Planning Application 20/00934/FUL Comments on the proposal for the erection of new dwellings to the rear of The George Inn, 5 Sandford Road, Littlemore, OX4 4PU.

**Land to rear of George Pub
Littlemore
KJD Investments
Units 4 & 5
Proposed Elevations
190277 - A - 05 - 202**

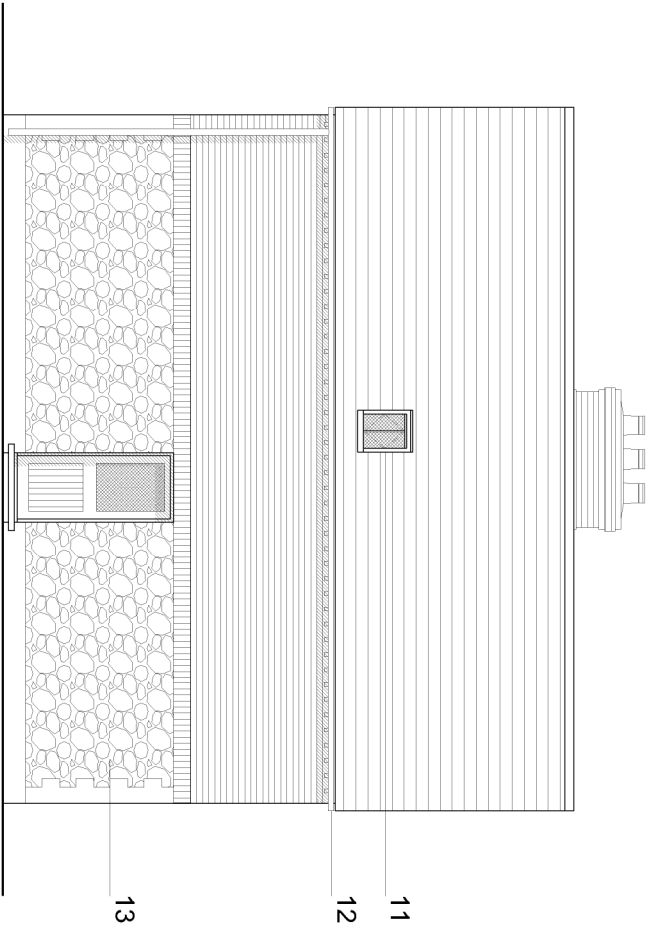
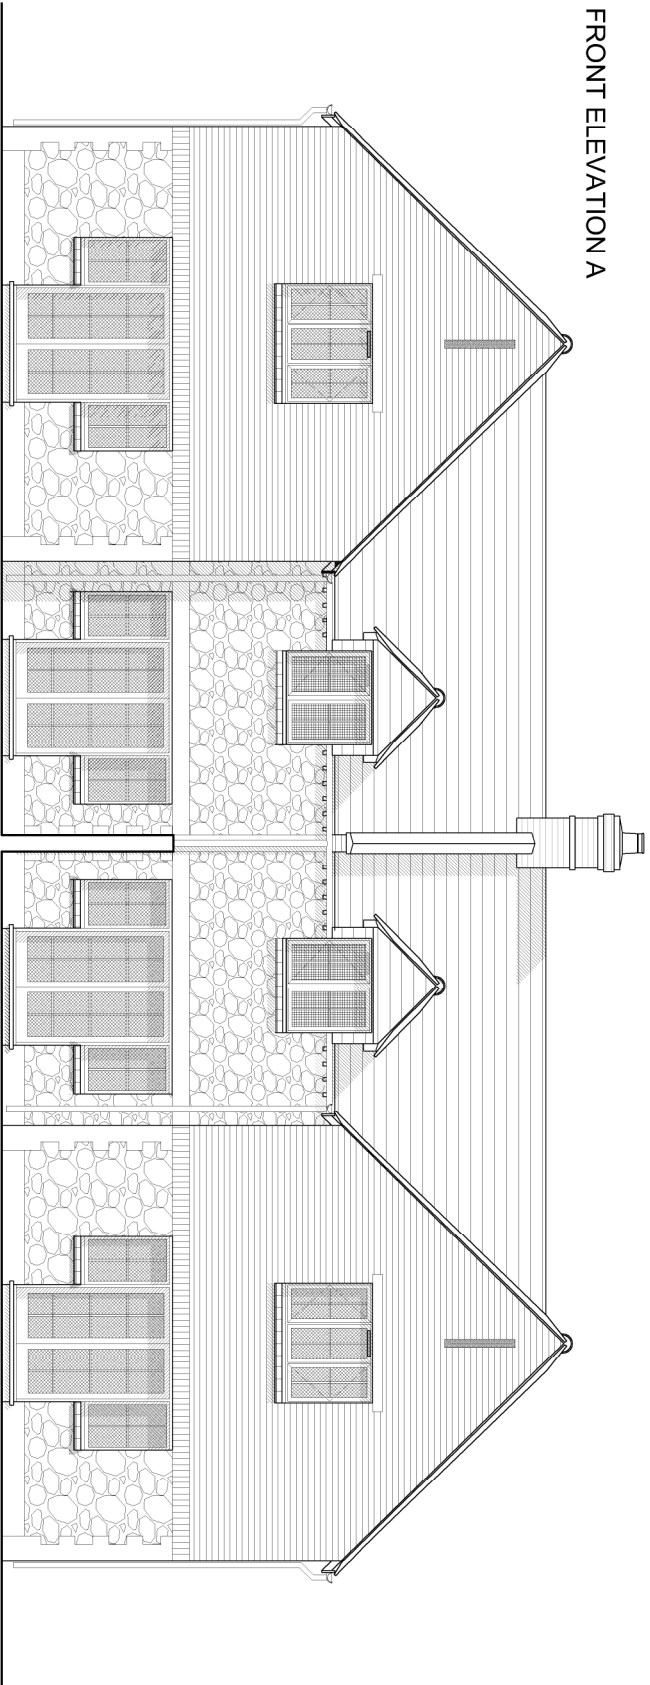
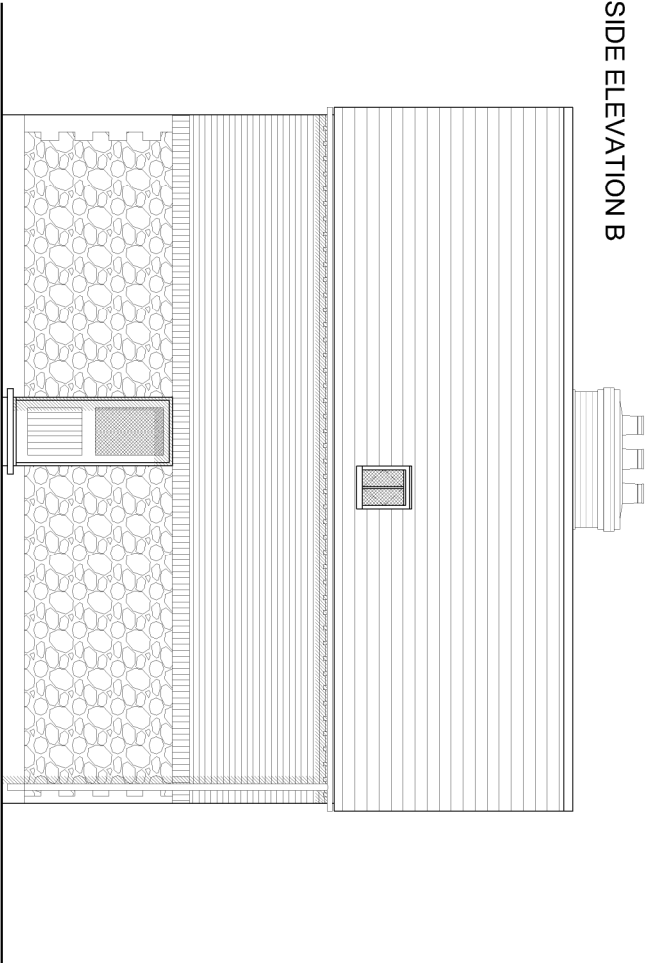
1. The contemporary style of the houses and choice of materials are not in keeping with the traditional style of architecture within the oldest part of the Littlemore Conservation Area. The large, dark aluminium framed windows and use dark timbers/ cladding impact adversely in relationship to the smaller, white framed windows divided by glazing bars which are characteristic of vernacular buildings nearby.

3. The larger houses have tall chimneys. The design statement does not specify the function of these. If these are for open fires, this is not compatible with the local Low Carbon strategy.
